49 Hancock Street - Revision 1- Permit #201500151

I have completed my initial zoning review for the revised project and at this point I need more information before I can sign off. I need:

2.2

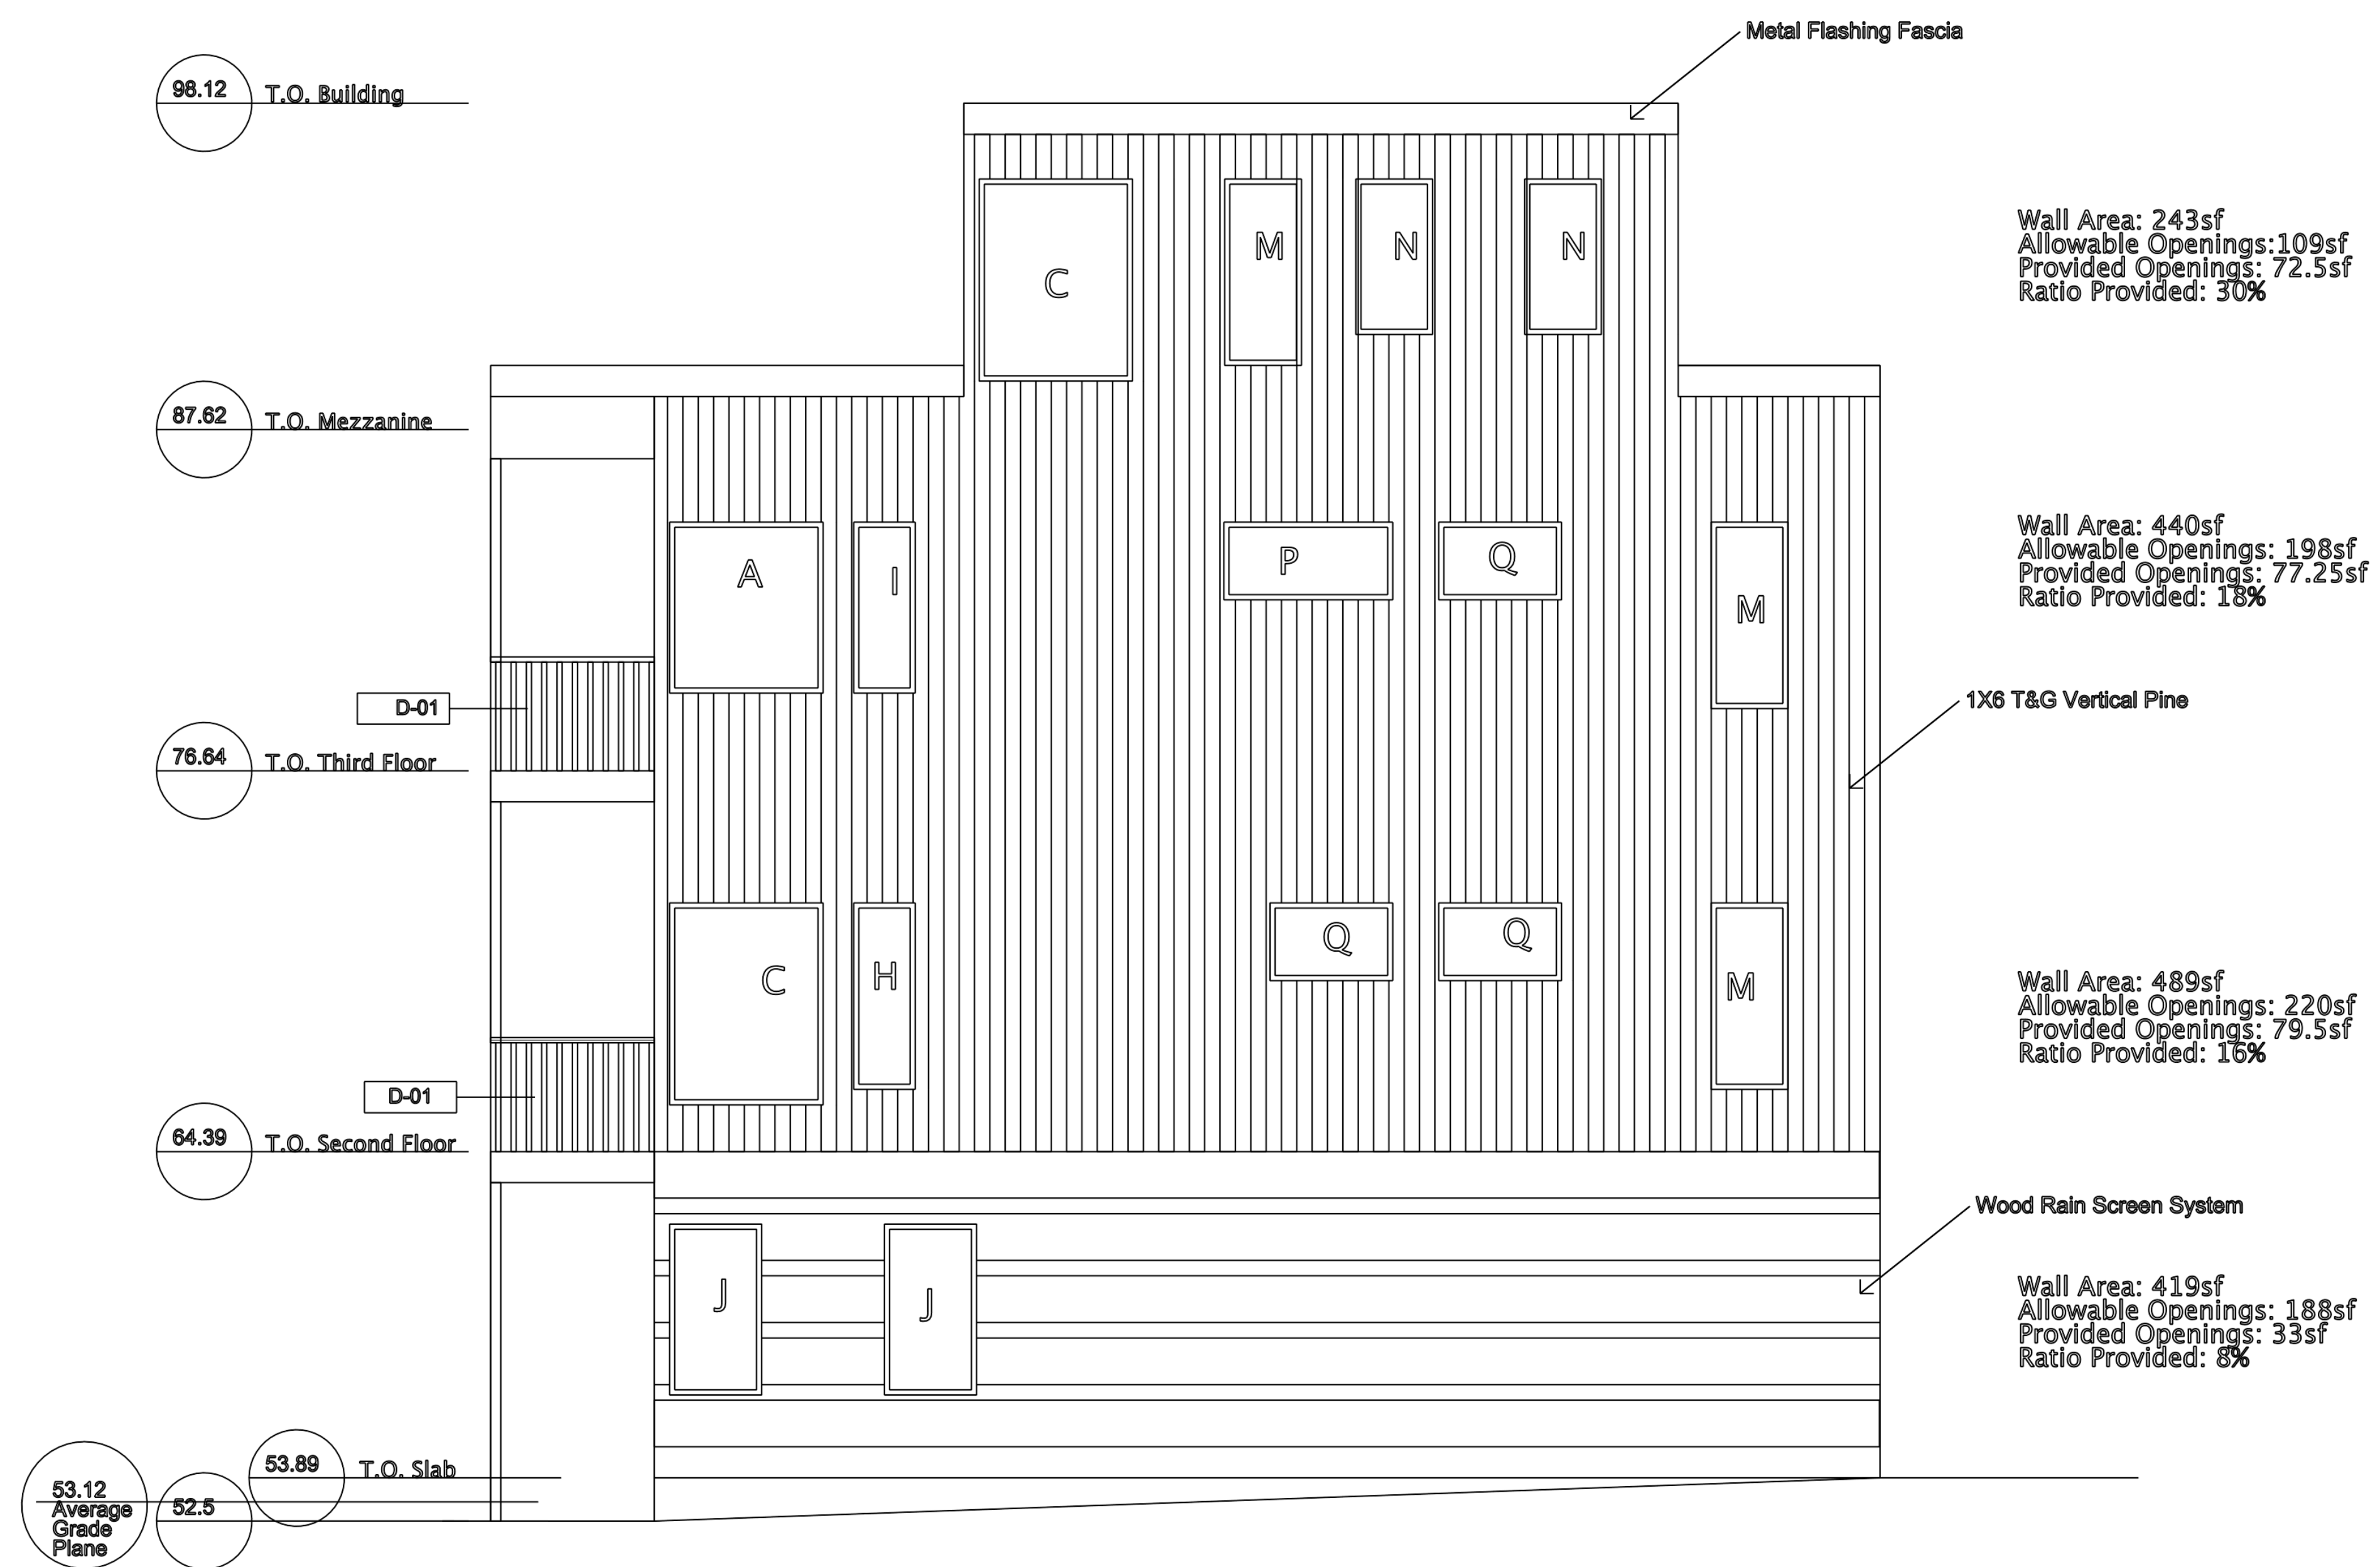
1. Existing footprint is 1883 sf. What is the proposed square footage of the existing structure and addition?
2. On the second and third floor plans, the use says flex area and storage. What is meant by flex area?
3. Plans A1.1, A1-2 and A1.3 show the first second & third floors. There are no plans for the mezzanine level or the roof as shown on the plans LS-1 and S1-1. I need to know what the
4. There are no elevation plans to replace A2.1 & A2.2..
5. There is no section plan to replace A3.1

- 1) Existing structure (1883sf) plus additional footprint (497sf) = a total building footprint of 2380sf
- 2) There was no specific meaning to the word "flex". Consider this just storage.
- 3) I have attached mezzanine plan (A1.4), 3 elevation sheets (A2.1, A2.2, A2.3), sections (A3.1, A3.2), and 2 detail pages (A4.1, A4.2)
Let me know if these are not coming through.
- 4) see above.
- 5) see above.
